A46 Newark Bypass

Scheme Number: TR010065

**Statement of Common Ground with
Newark And Sherwood District Council**

Regulation Number:	8(1)(e)
Planning Inspectorate Scheme Reference	TR010065
Application Document Reference	7.30
Author:	A46 Newark Bypass Project Team, National Highways

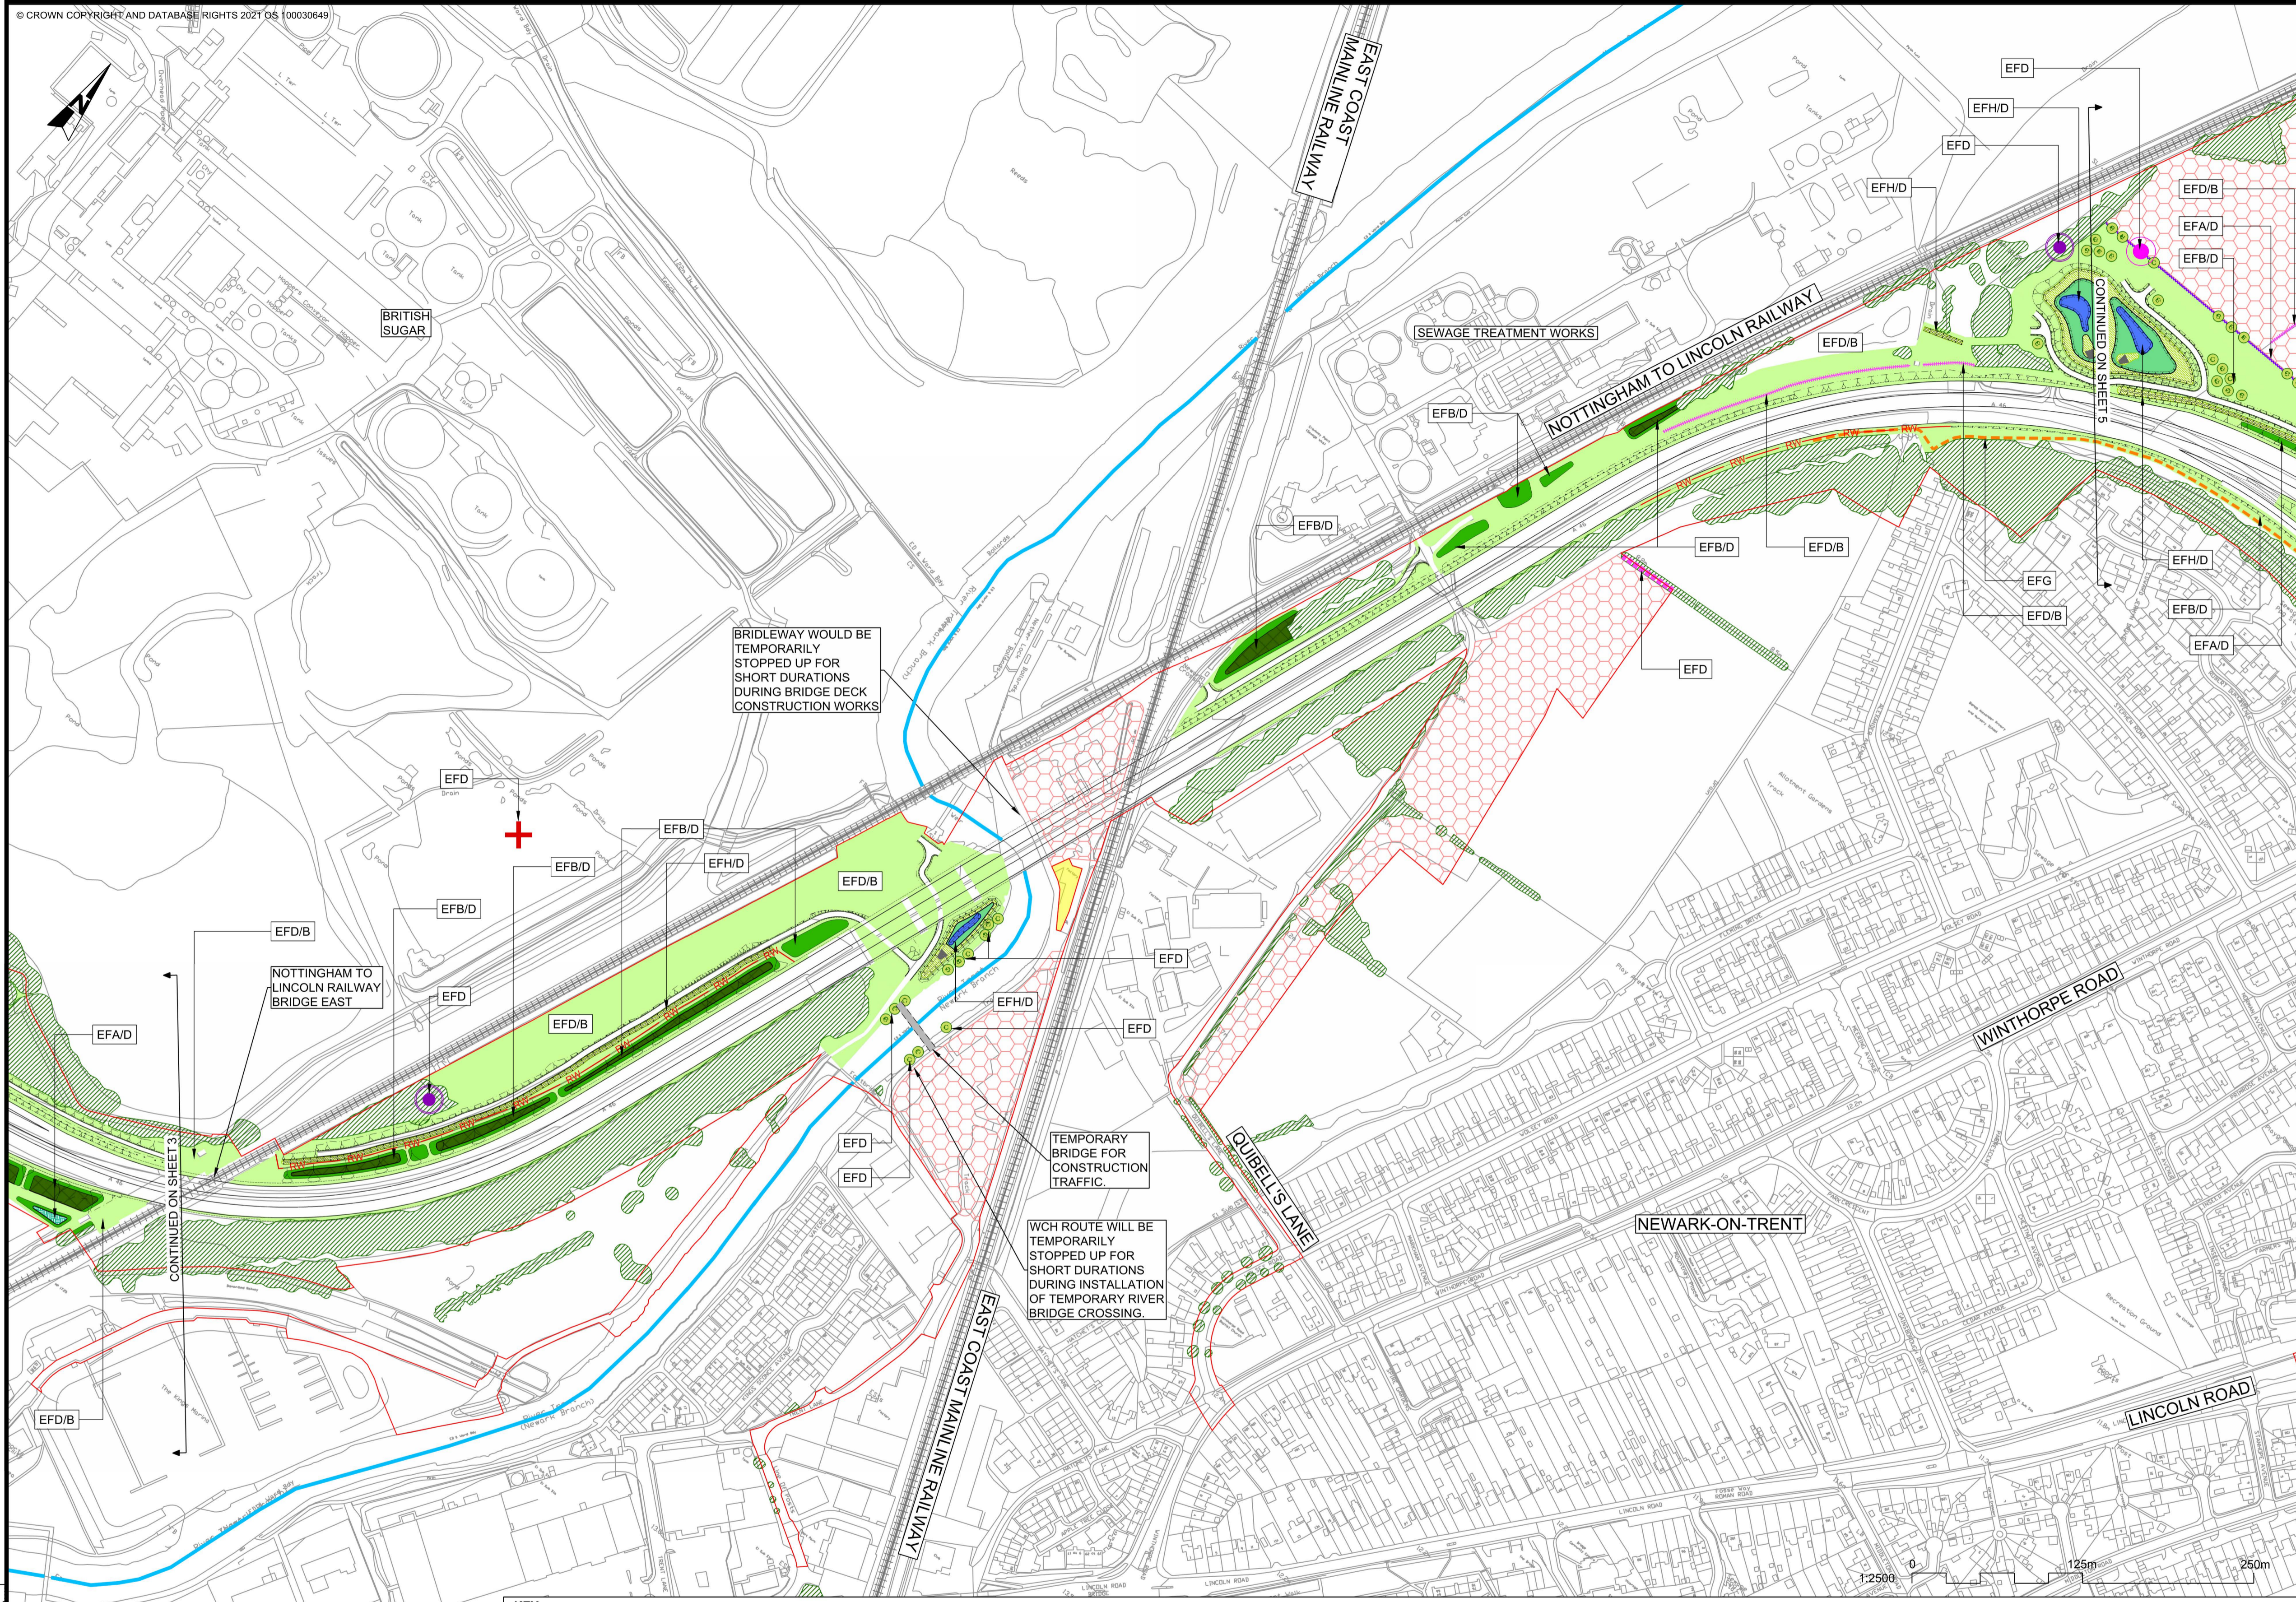
10.	Design (including justification for any flexibility being sought)	Chapter 2 The Scheme of the Environmental	<p><u>Cattle Market flyover</u></p> <p>On the fly-through video the structure of the elevated over-pass at the Cattle Market junction appears as a stark and imposing concrete structure. This may be</p>	<p>Consideration has been given to the aesthetic finish of the structure during the design development to help to reduce the visual prominence of the structure and to reflect finishes on existing structures such as that of Smeaton's Arches just to</p>	Under Discussion	16/10/2024

Issue No.	Issue	Document Reference	Newark and Sherwood District Council's Position	The Applicants Position	Status	Date status confirmed
		Statement [APP-046] 6.2 Environmental Statement - Figure 2.3 Environmental Masterplan [AS-026]	in part due to the animation which depicts it as being very bright in colour and therefore standing out vividly. The Council would want to understand proposals to ensure the visible impact of the final structure is minimised and/or mitigated as far as practicable.	the north of the new junction. Further details of these can be found within Chapter 2 The Scheme of the Environmental Statement [APP-046] and 6.2 Environmental Statement - Figure 2.3 Environmental Masterplan [AS-026]. Planting of trees and shrubs has also been considered and incorporated wherever feasible to help break up the visual mass of the structure, with planting softening the built form and aiding screening over time, particularly from properties such as those in Sandhills Park affording near distance views. The assessment of landscape and visual effects and associated design and mitigation measures are described in 6.2 Environmental Statement - Figure 2.3 Environmental Masterplan [AS-026] and presented in 6.2 Environmental Statement - Figure 2.3 Environmental Masterplan [APP-026]. Part of the Detailed Design process will be to define the finish of the retaining walls forming the Cattle Market Flyover. This will be a masonry type façade and not a bare concrete finish.
